218984

Appendix A

Record and Response to Submissions

Extracts from Government agency and authority submissions received in relation to SSD 18_9270, and a response to each of these matters, has been outlined in the table below. It is noted that no submissions were received from the general public.

Tower built form relationships - DRP 07 Proposal

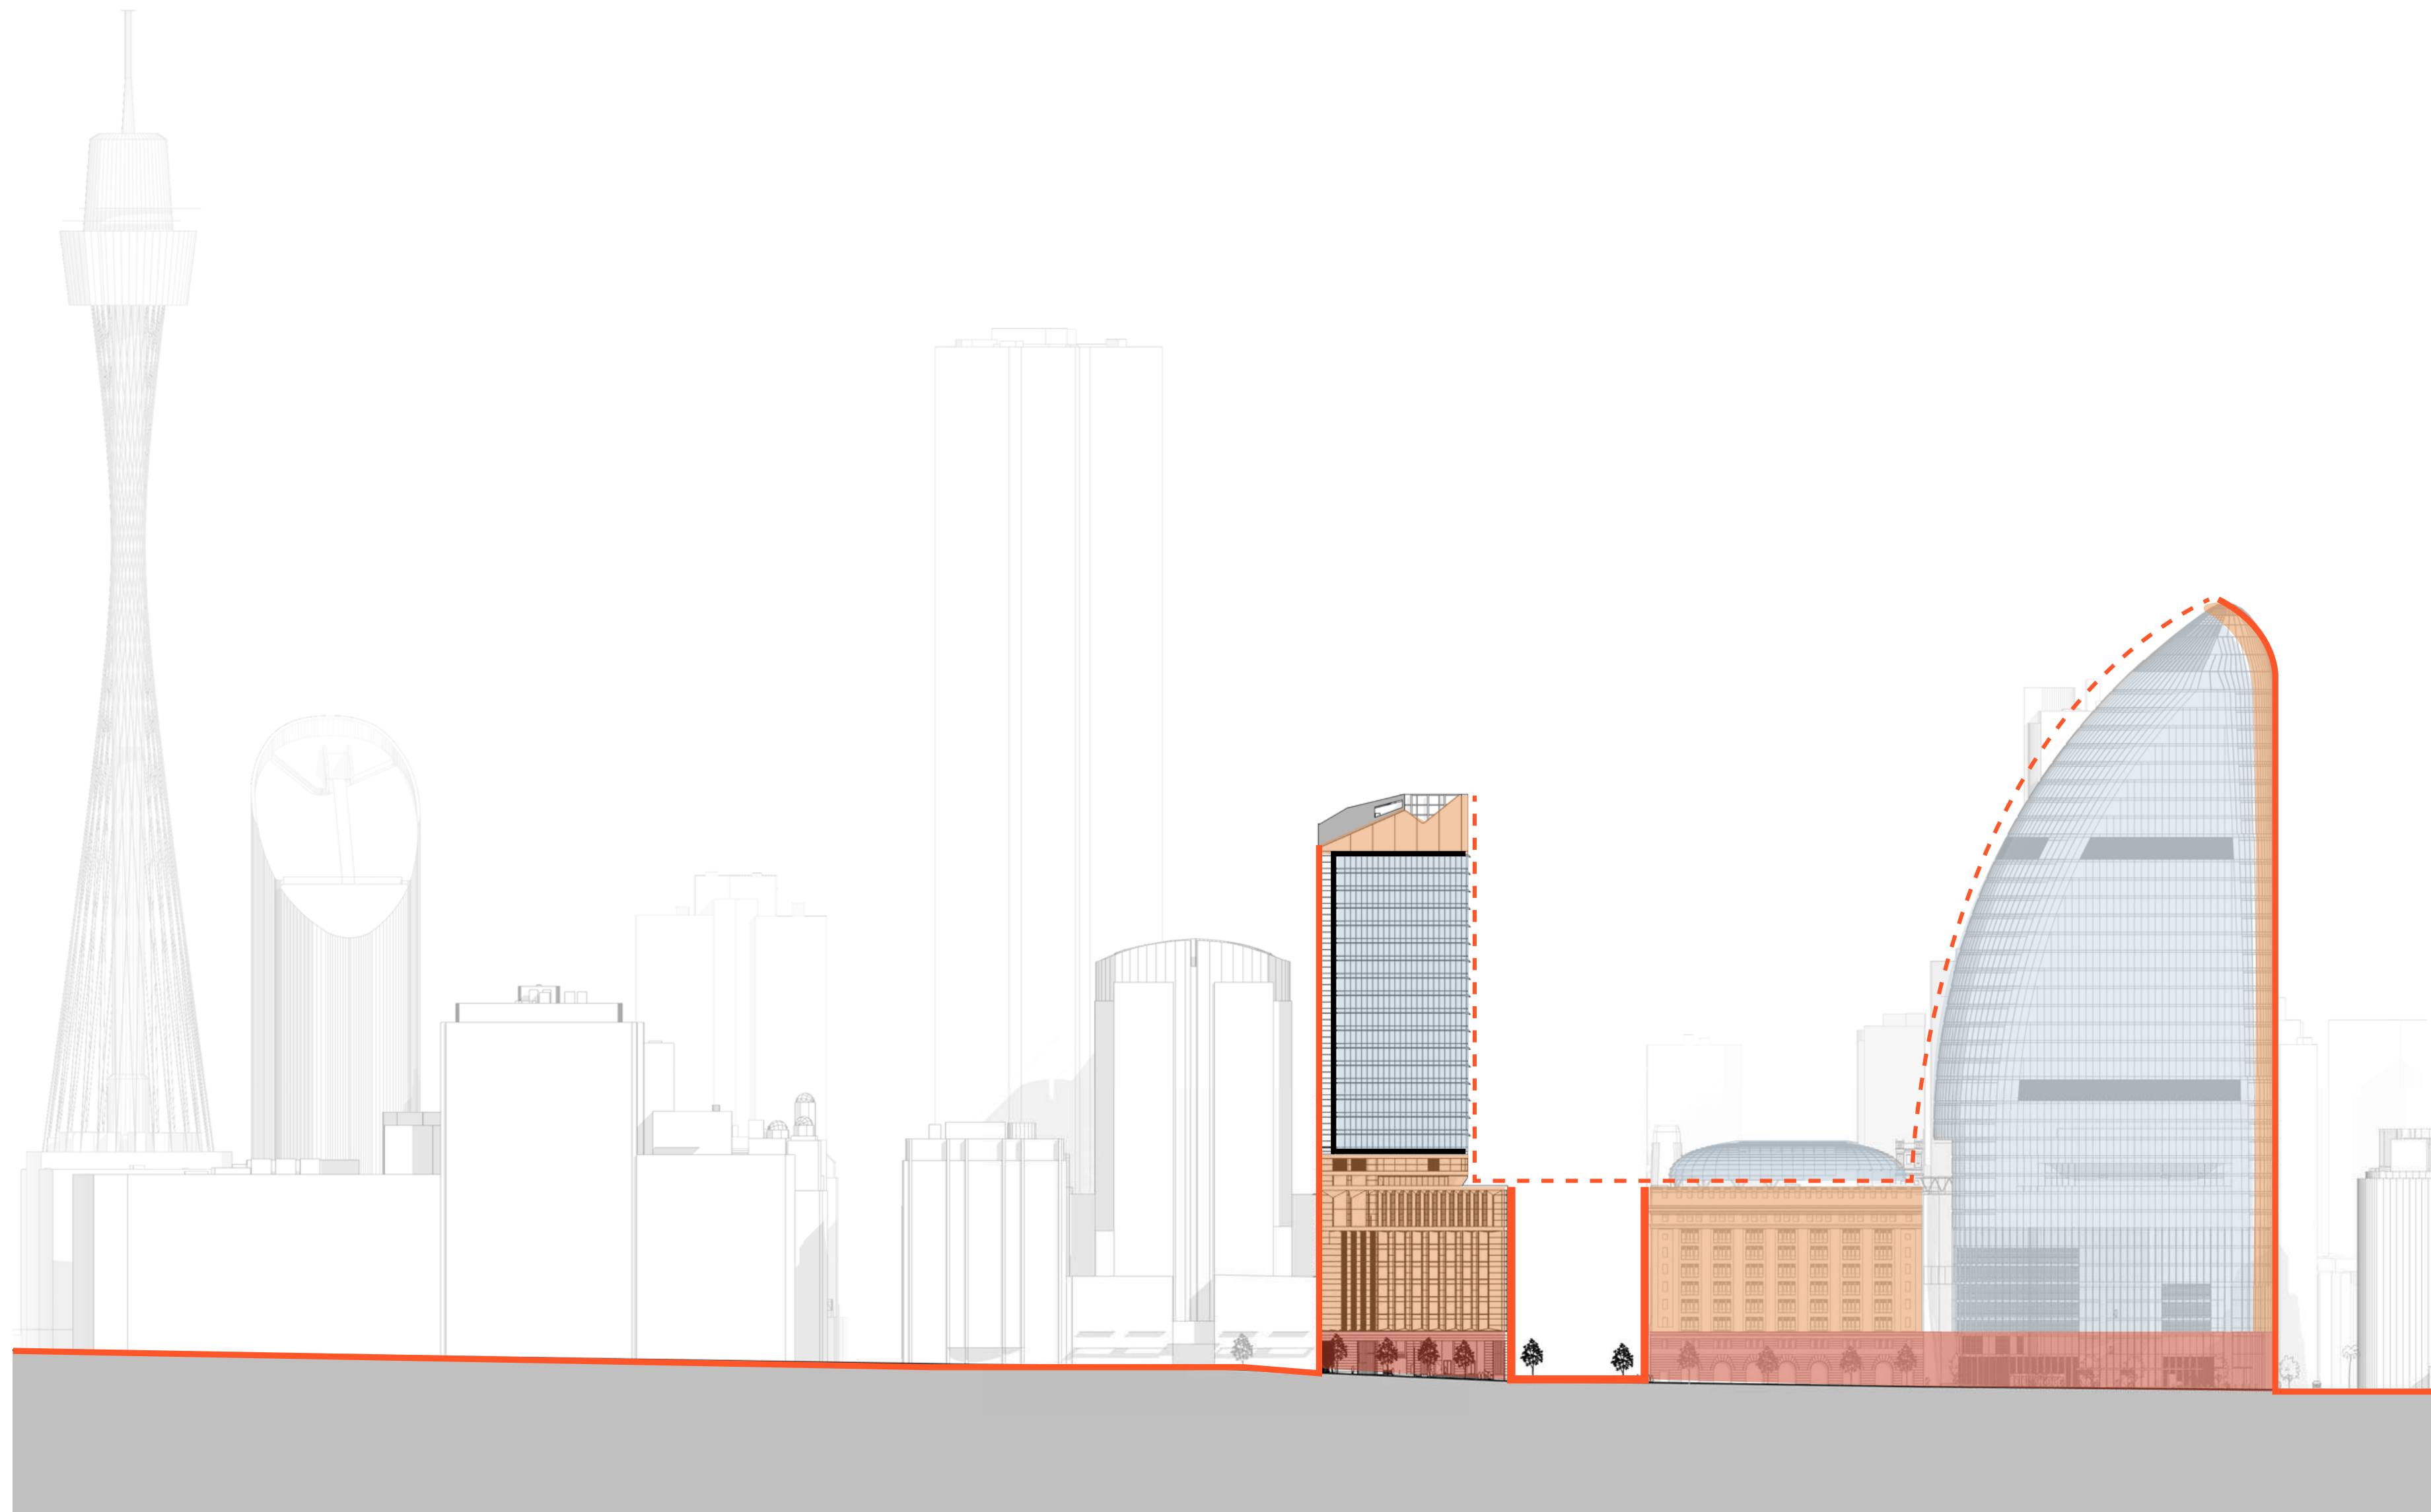
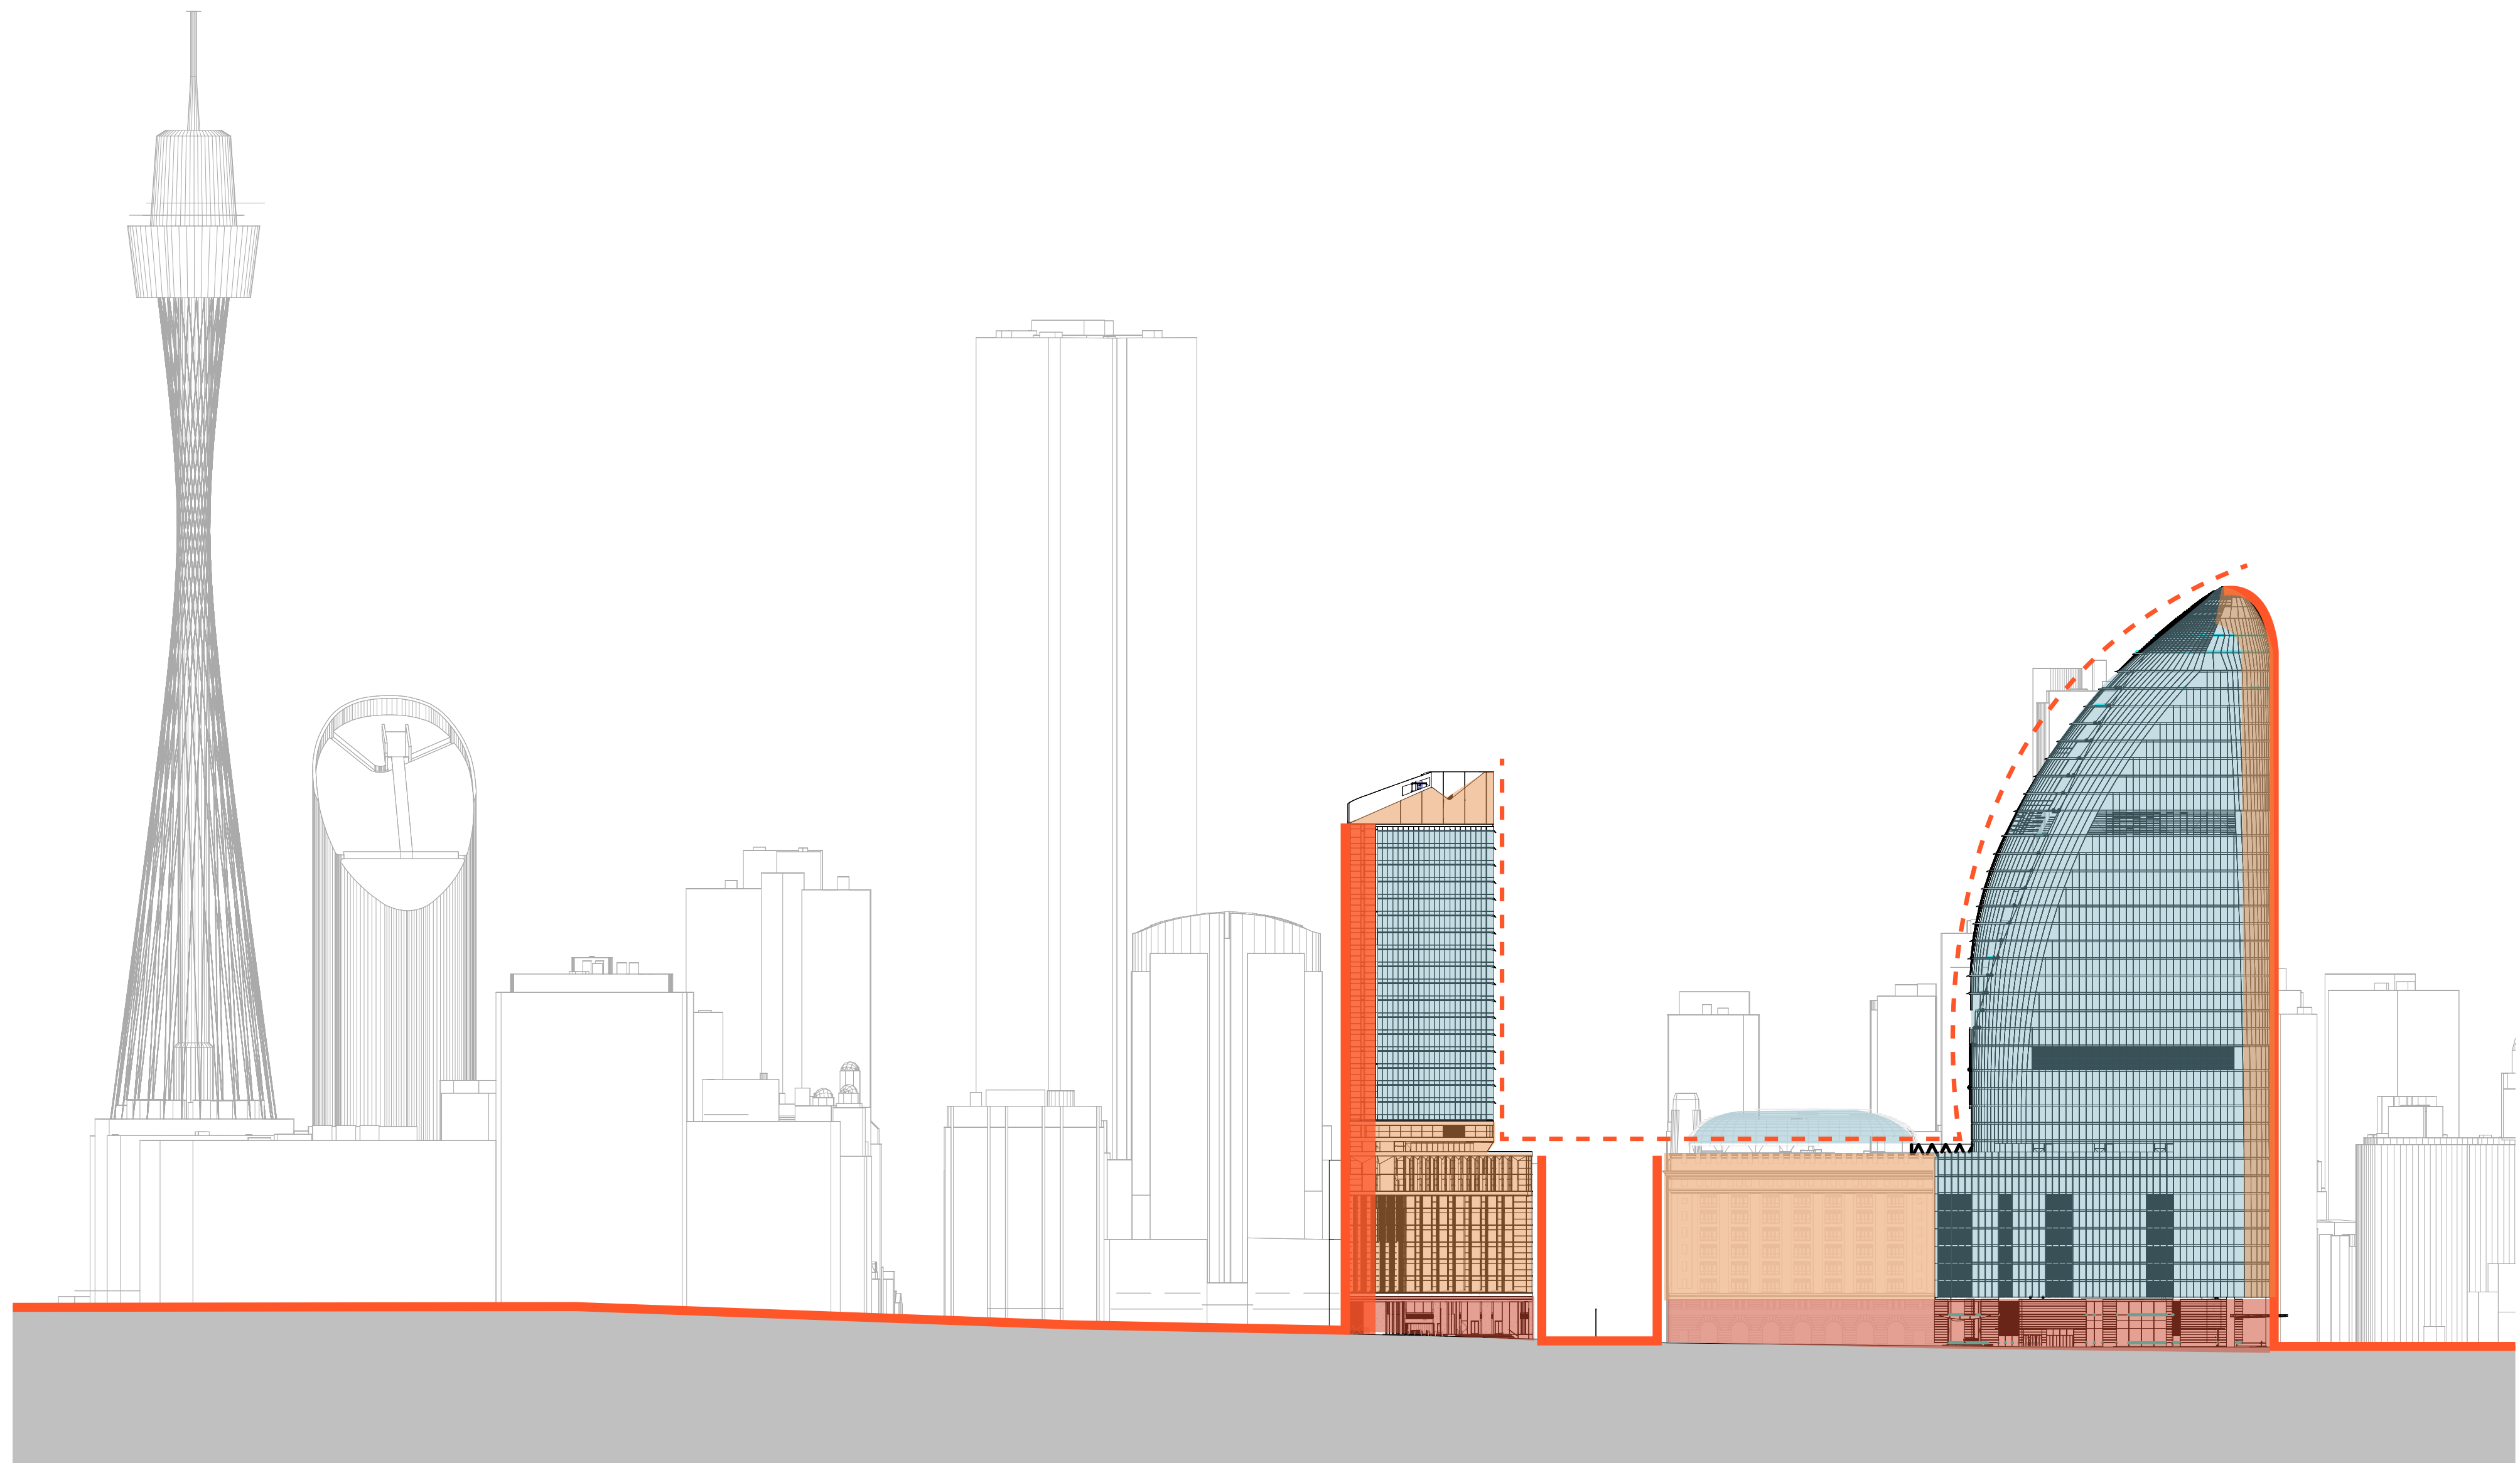
<p><i>b) mitigate the bulk and form of buildings, including the appropriateness of, and options for, any tower setbacks within the maximum building envelopes (including amendments to approved building envelopes under Amending Concept Proposal SSD 9347 under assessment).</i></p>	<p>Each of the issues below are discussed in greater detail in the main RTS report, with summaries provided below.</p> <p><u>Existing character</u></p> <ul style="list-style-type: none"> • The scale of the proposal is considered contextually appropriate as it reinforces the city's status as a global city, in-line with neighbouring 8 Chifley Square and the Deutsche Bank Building. • The proposal is not out of context in its footprint and relationship to the streetscape; • That this part of the city is not defined by typical podium and tower forms. • There is also significant variation in the street wall heights and setbacks along Martin Place, as well as the benching of the Precinct from east to west with each block forming a subtle room within the larger space of Martin Place. <p><u>Approved building envelope</u></p> <ul style="list-style-type: none"> • The approved Concept Proposal discussed the appropriateness of tower setbacks when considering potential design responses for the maximum building envelope, and developing the planning and design framework to be addressed at the detailed design phase of the development. The Concept Proposal determined that, in line with the context of the site, an appropriate design response could be achieved in the absence of tower setbacks. It was considered that the North and South Sites should establish a distinct character at the threshold locations of the Martin Place Station Precinct, requiring built form on the North and South Sites to vary the typical setback requirements for towers above a podium in Central Sydney. The North Site, particularly, should also reinforce the spatial enclosure of Chifley Square and Richard Johnson Square and align with the towers adjacent to the east on Hunter Street, to continue the scale and mass in the same proportions as these neighbouring towers. • In the assessment of the approved Concept Proposal, the GANSW confirmed that the rigorous application of setbacks may not deliver the best outcome in this part of the city and, in that respect, the DRP should be regarded as the mechanism through which to test the performance and quality of the proposed design against the intent of setbacks across the site. <p><u>Detailed proposal</u></p> <ul style="list-style-type: none"> • The detailed built form of the North Site represents a lesser building than what could otherwise be provided within the approved building envelope. The form and scale of the development has been refined from the maximum building
